Norwell Solar Farm Steering Group

**Application by Elements Green Trent Limited for an Order Granting
Development Consent for the Great North**

Road Solar and Biodiversity Park (GNR Project)– project ref. EN010162

Deadline 3. Written Summary of Oral Submissions ISH/3

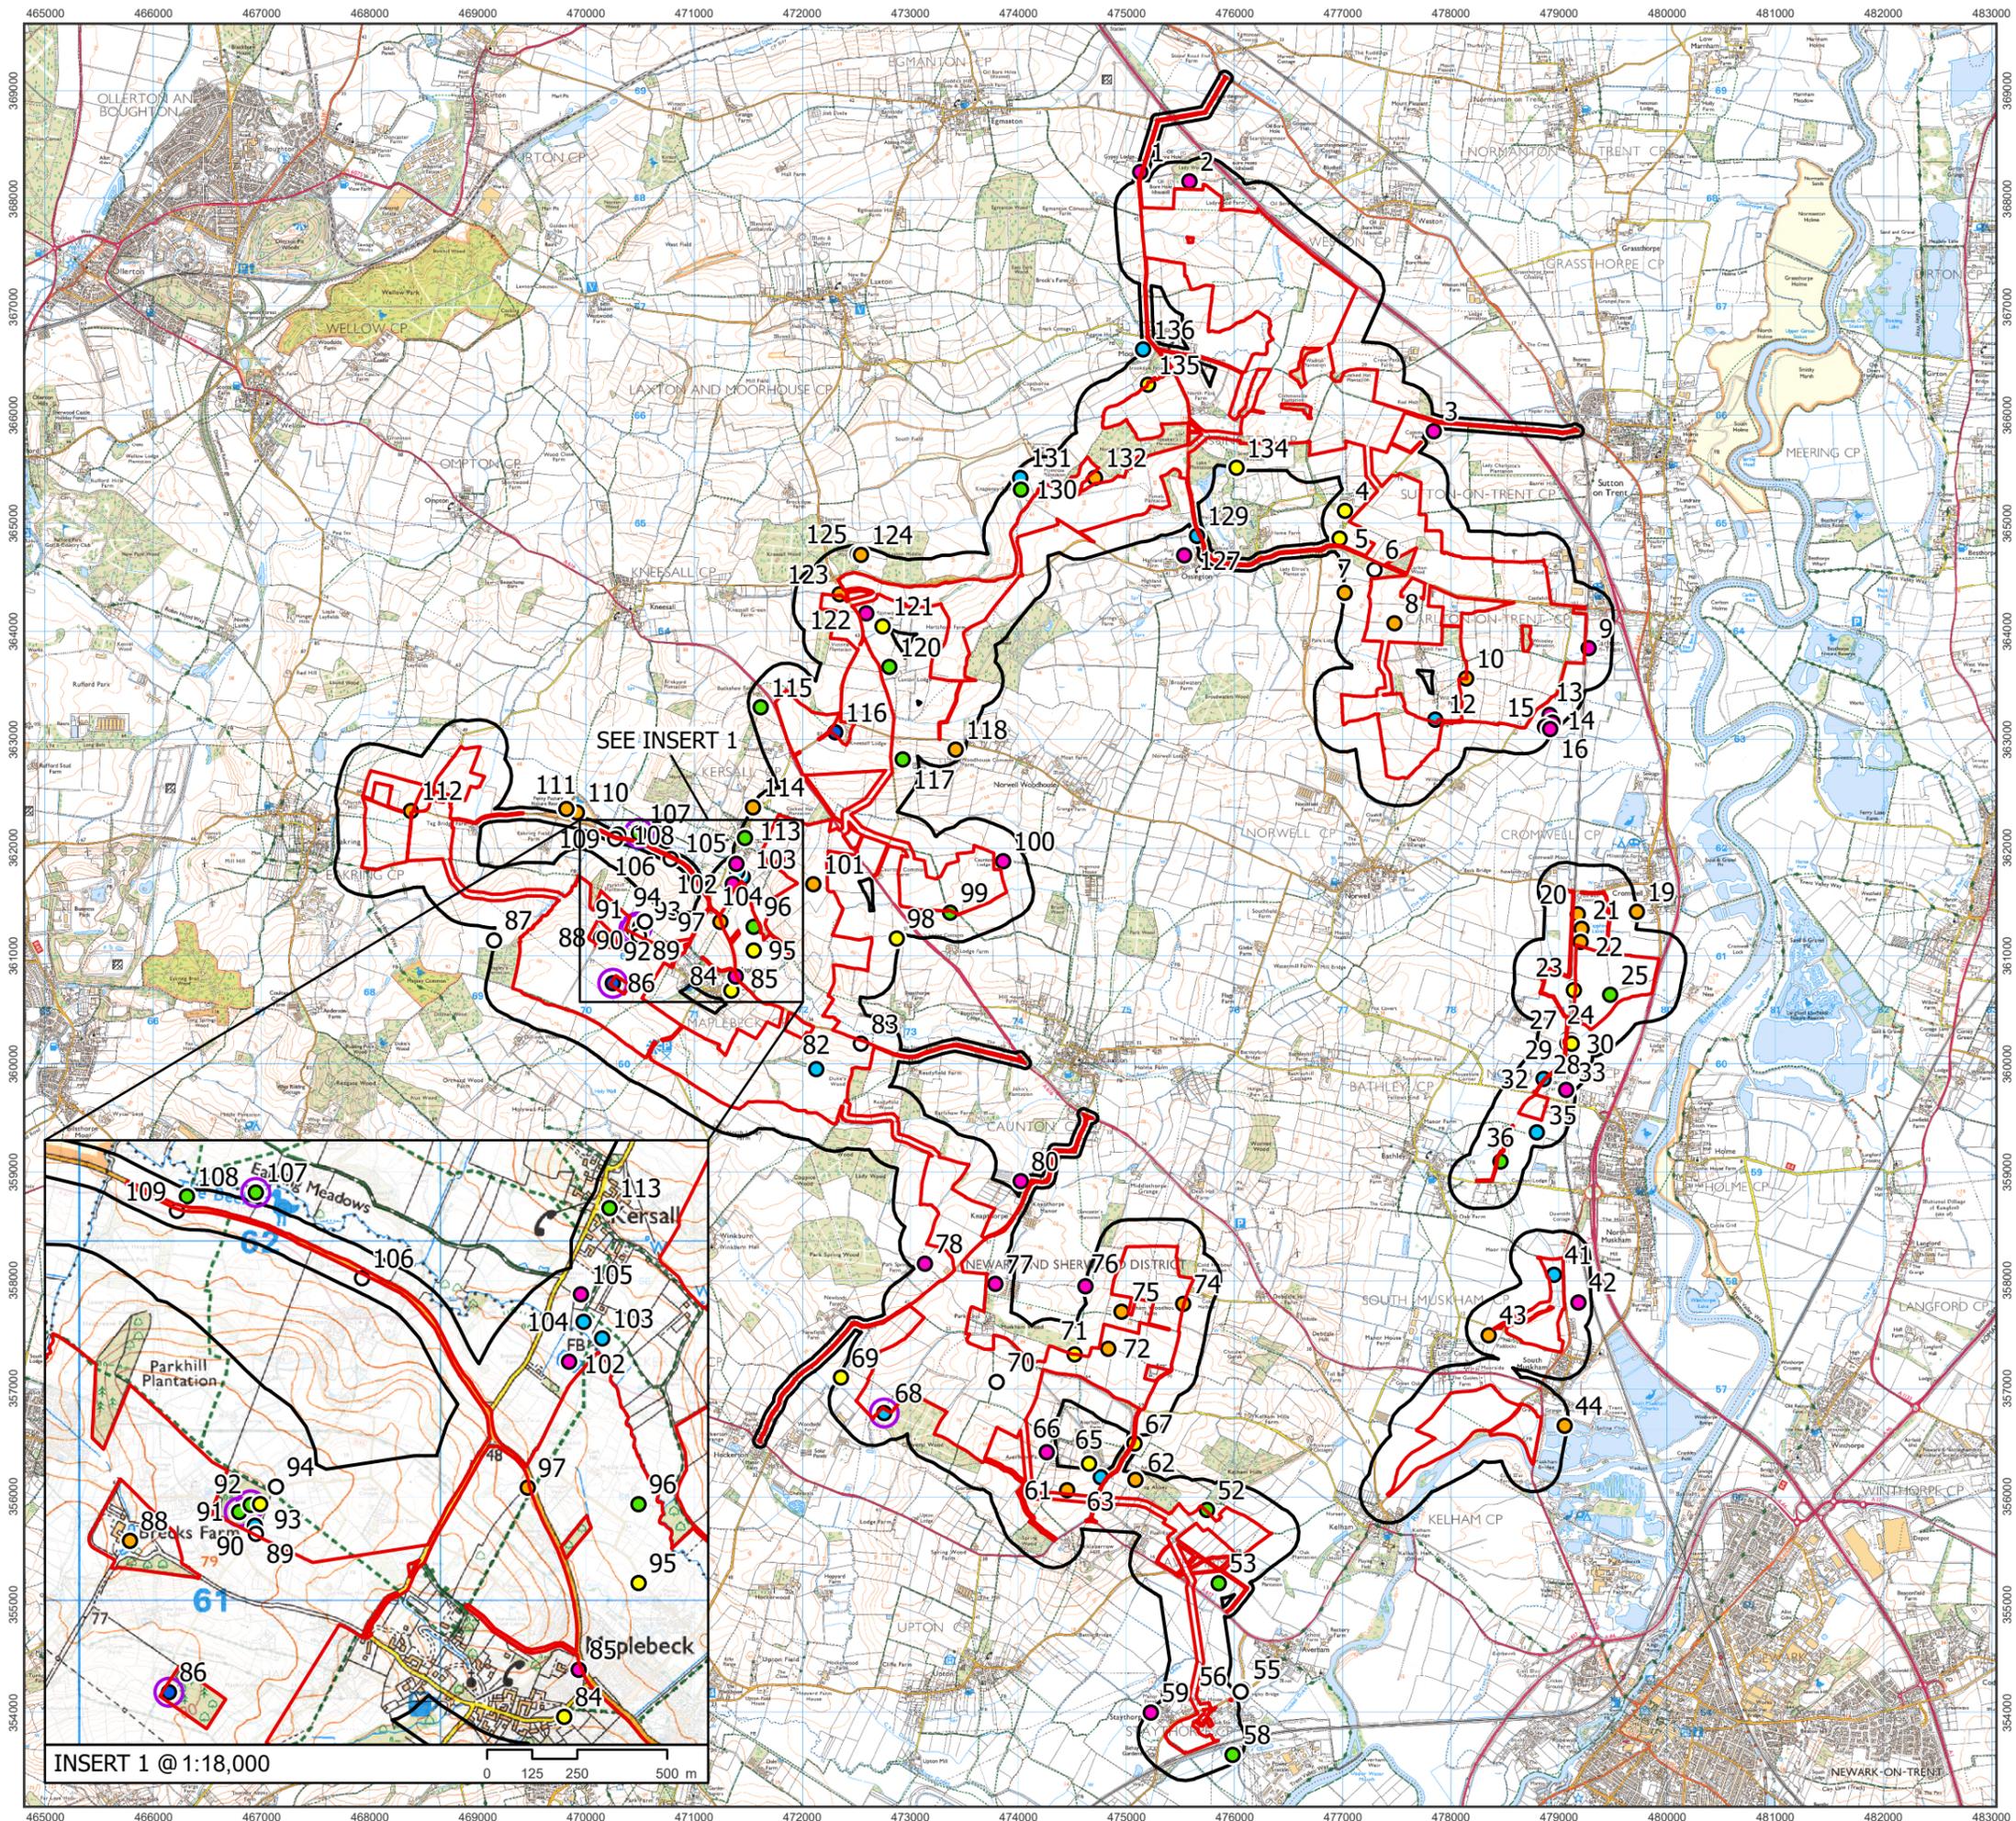
2.1 This water feature was designated as Pond 116 in the Technical Appendix A8.7 Great Crested Newt Baseline (GCN) [APP-220](#). Below is an edited graphic from that document showing its location. It is within the grounds of Kneesall Lodge, Northwest of Norwell Woodhouse.

- 2.2 The map pin is coloured blue signifying that it has a Habitat Suitability Index rating as Excellent for GCN, though on the day of the survey of the pond, it tested negative for GCN DNA.
- 2.3 In terms of how this location is to be affected by the development, the below graphic is taken from the Applicant's Masterplan, demonstrating its proximity to planned panelling.
